ADVICE RESPONSE: Taronga Tin Project

Stage: Environmental Impact Statement

Development Application: SSD- 74389710

I refer to the Taronga Tin Mine - Environmental Impact Statement (EIS) submitted to the Resources Regulator on 2 of October 2025 (SSD-74389710). Based on the review of the EIS the Resources Regulator requests further information to address the matters below.

Figure 3.5.1
NORTHERN WRE PLAN VIEW -
PAF / UNC CELL

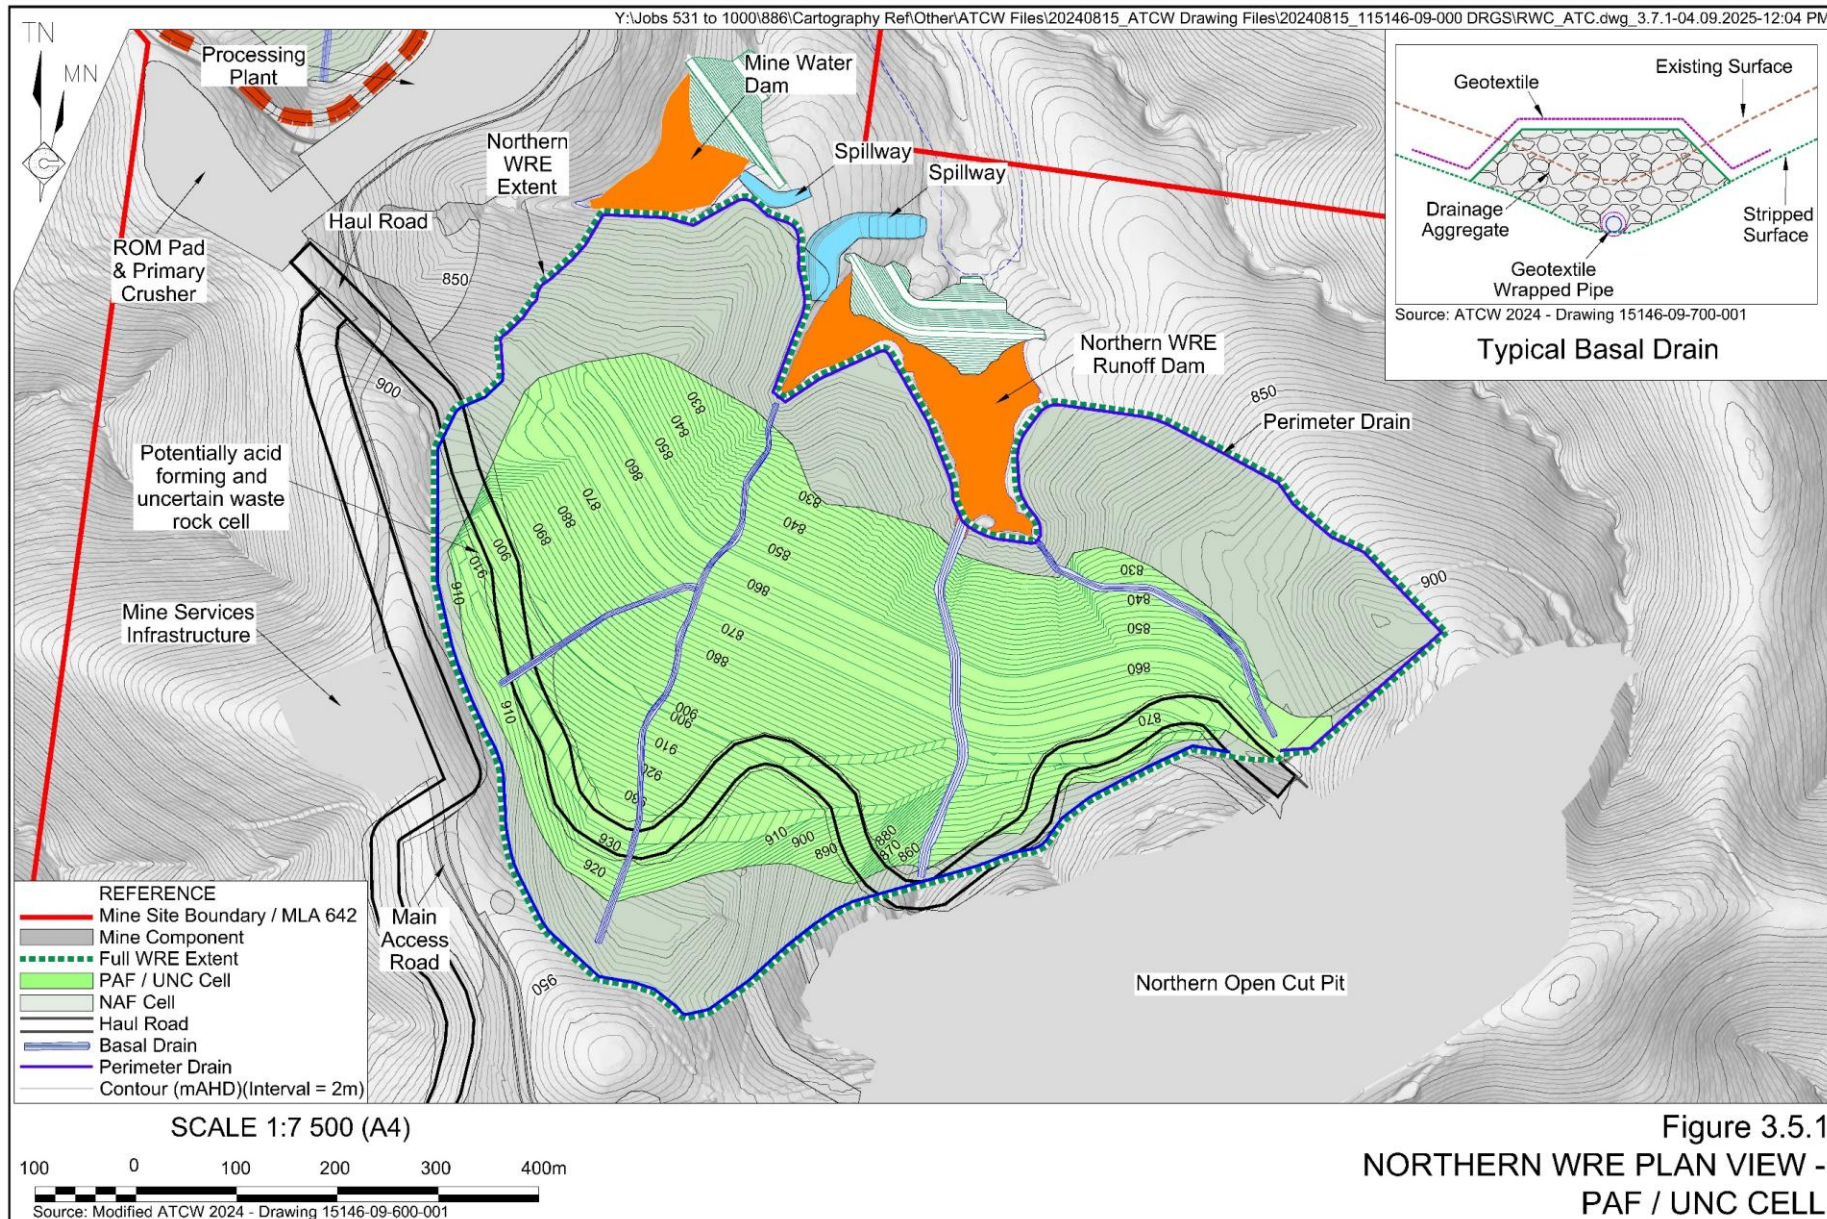
- describe how long term landform stability principles (including geomorphic design) will be incorporated for all landforms (e.g. geotechnical stability design, erosion modelling, landform design concepts, quality assurance processes etc.) including where potentially acid forming materials will be encapsulated based on the details provided in Section 3 (Figures 3.5.1 to 3.5.4) of the EIS.

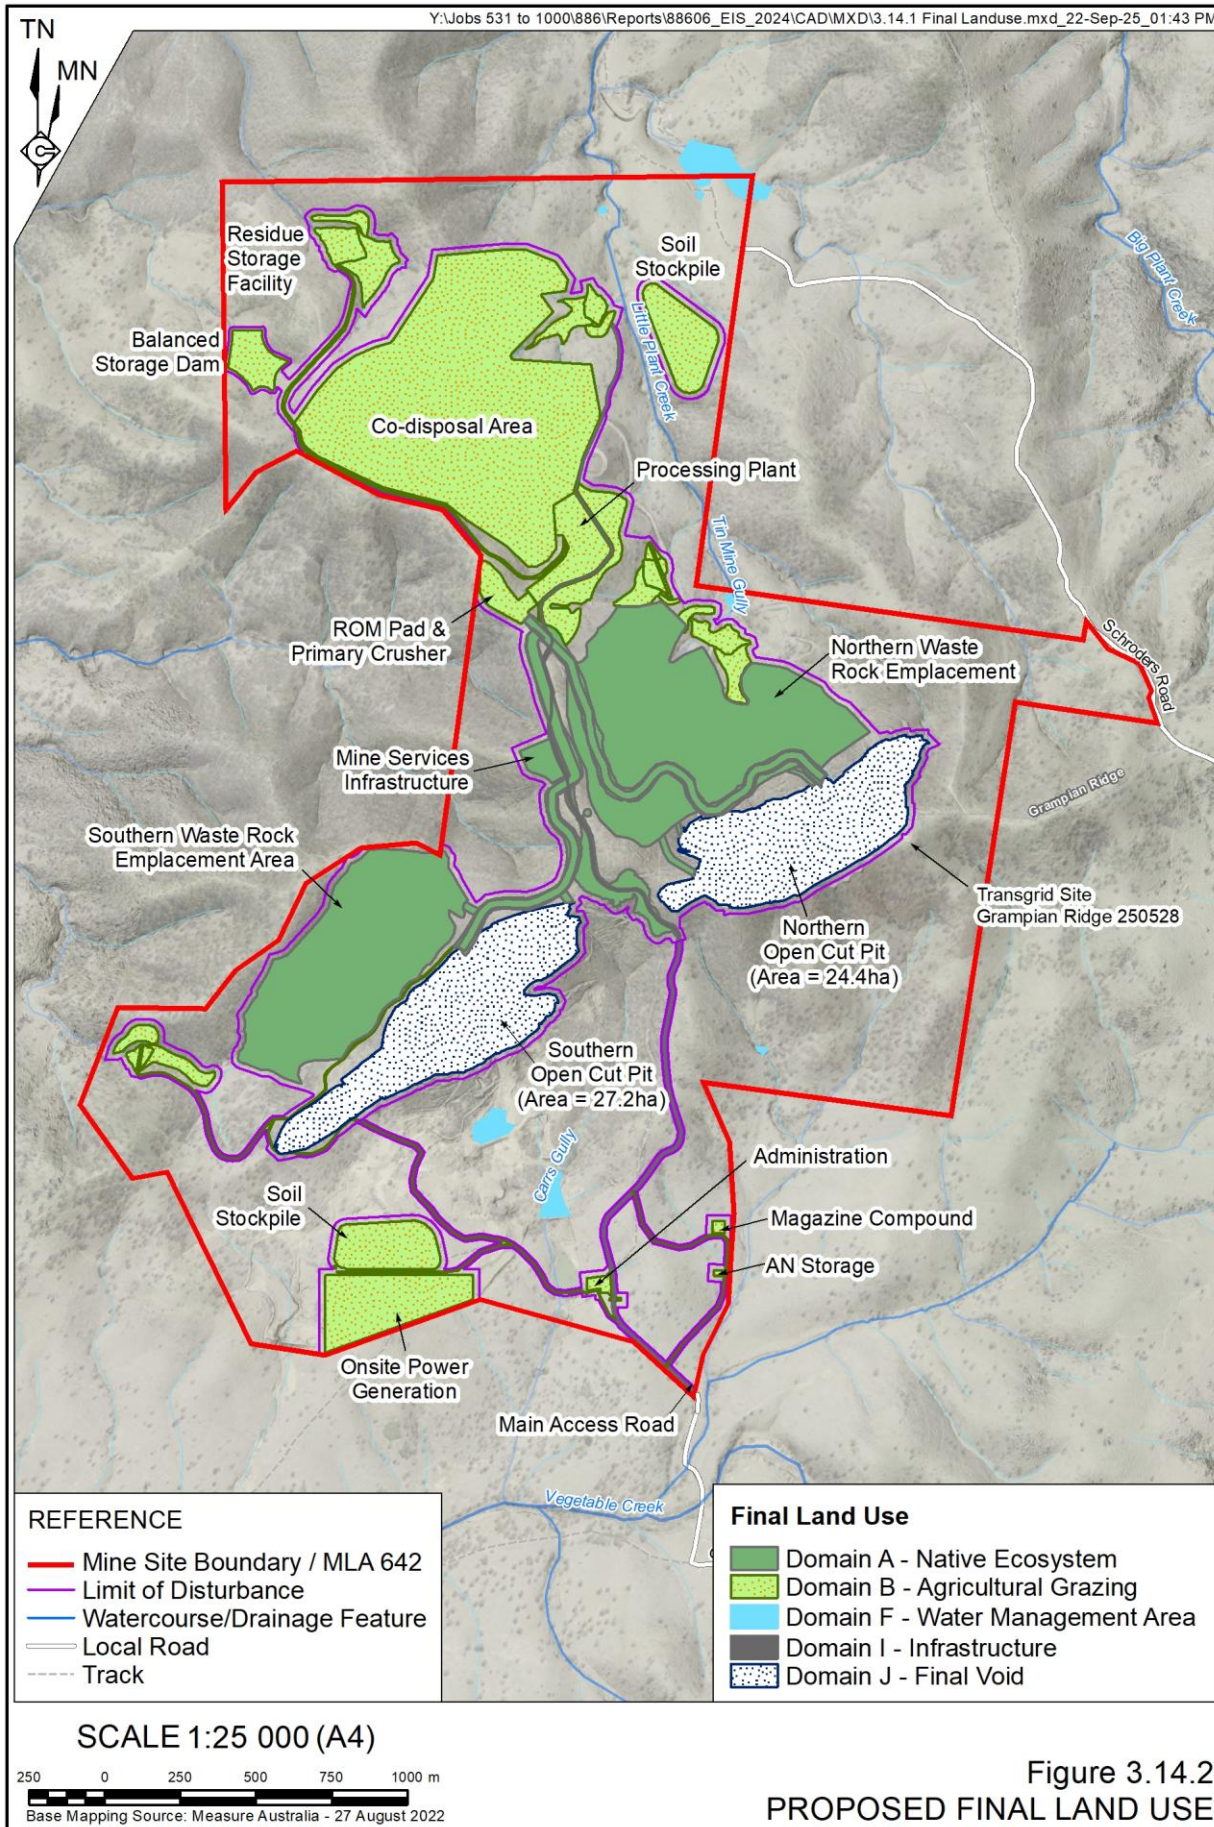
- Review and clarify the final land use of the residue storage facility (RSF) and Co-disposal area, which are currently proposed as “agricultural grazing” in Figure 3.14.2. The review must consider the following:

- Appendix 22 "Geochemistry Characterisation and Assessment" states that the residue storage facility will be "revegetated to achieve the post mining land use of "native ecosystem"; and

- the potential risks to the integrity of encapsulation cover systems of these areas post closure due to the natural establishment of trees as well as proposed grazing activities.
